From: Kevin Moore
Sent: 02 March 2016 08:58
To: Adam Walker
Subject: RE: 2016/62/90502/W - Spring Head Farm

From: Mark Brotherton [<mailto:mark@foxarchitecture.co.uk>]
Sent: 01 March 2016 17:53
To: Adam Walker
Cc: Julie Townsend (julie.townsend5@btopenworld.com); Paul Crompton
Subject: 2016/62/90502/W - Spring Head Farm

Please find attached updated drainage proposals clarifying the Foul drain connecting to the foul sewer and surface water drainage to soakaway.

Client: Mr & Mr P Crompton	
Project: Spring Head Farm Scholes	
Drawing: Proposed Site Layout	
Date: Jan 2016	Scale: 1:200 @ A3
Drawing No: 1579/110	Rev: C

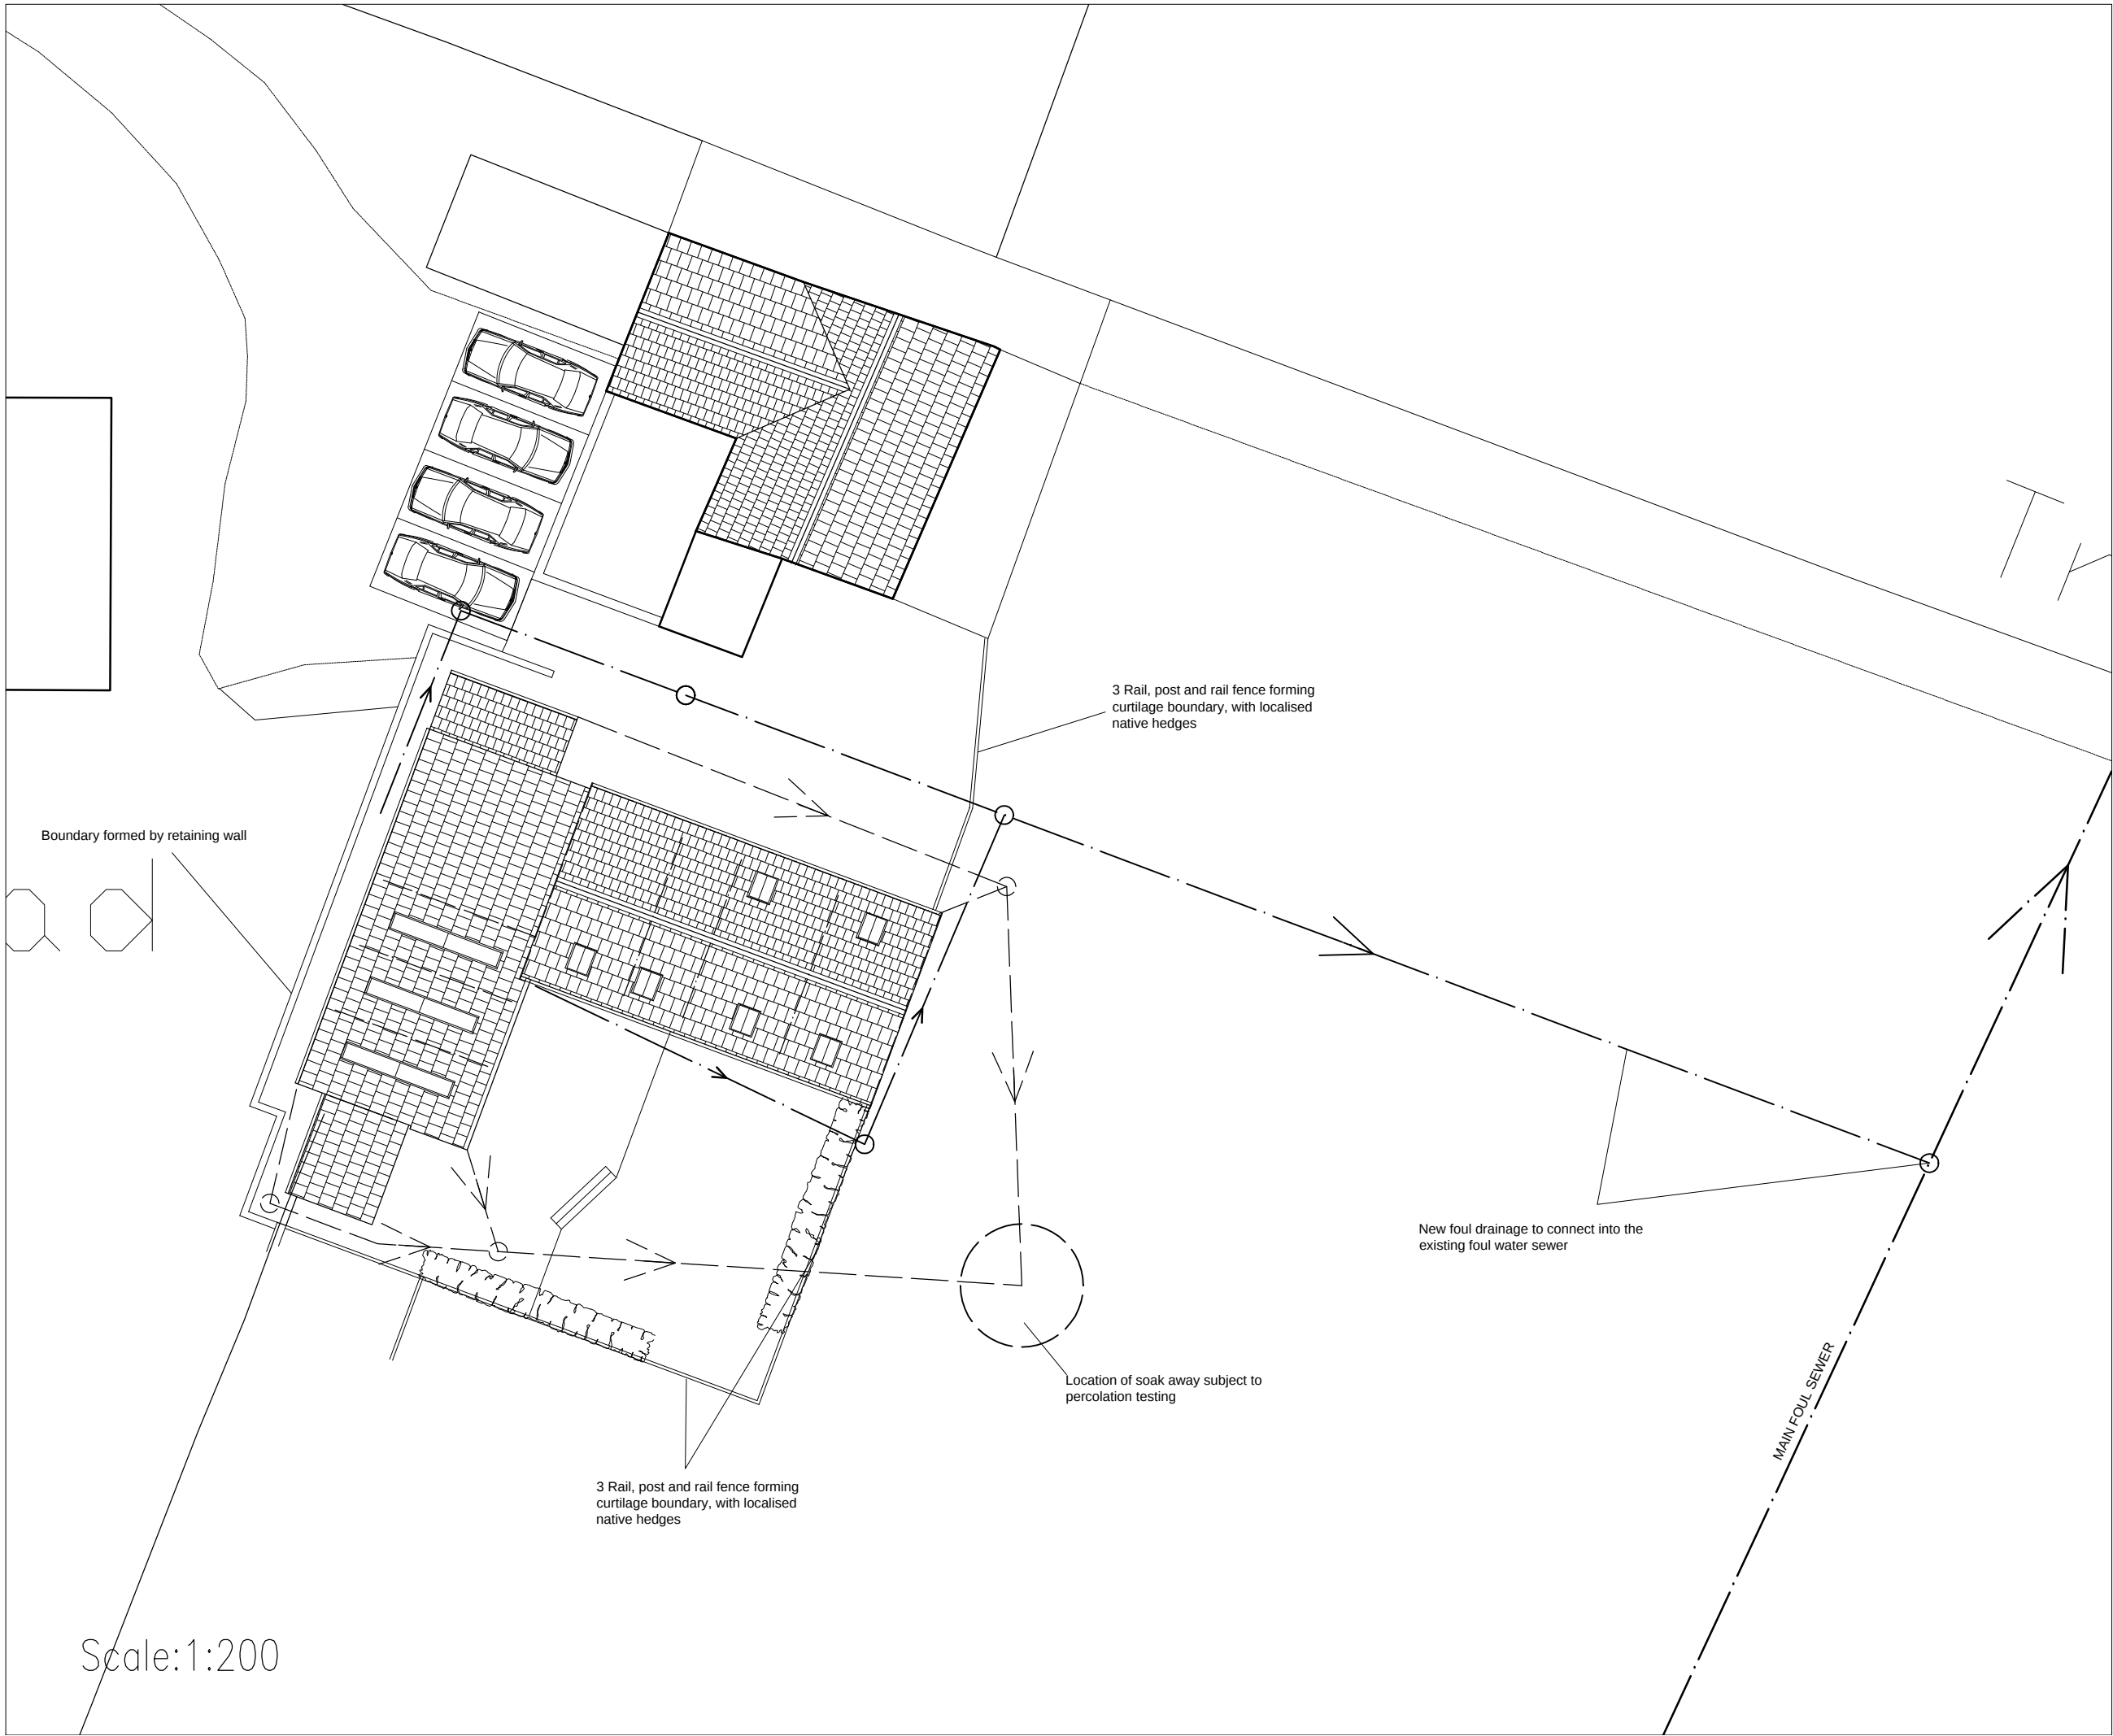
Drainage plan attached in response to your comments. They are now proposing to connect to a main sewer. I assume this addresses your concerns?

As this is the case there is no need for any drainage related conditions, but please put on the construction site hours footnote and EV charge point condition.
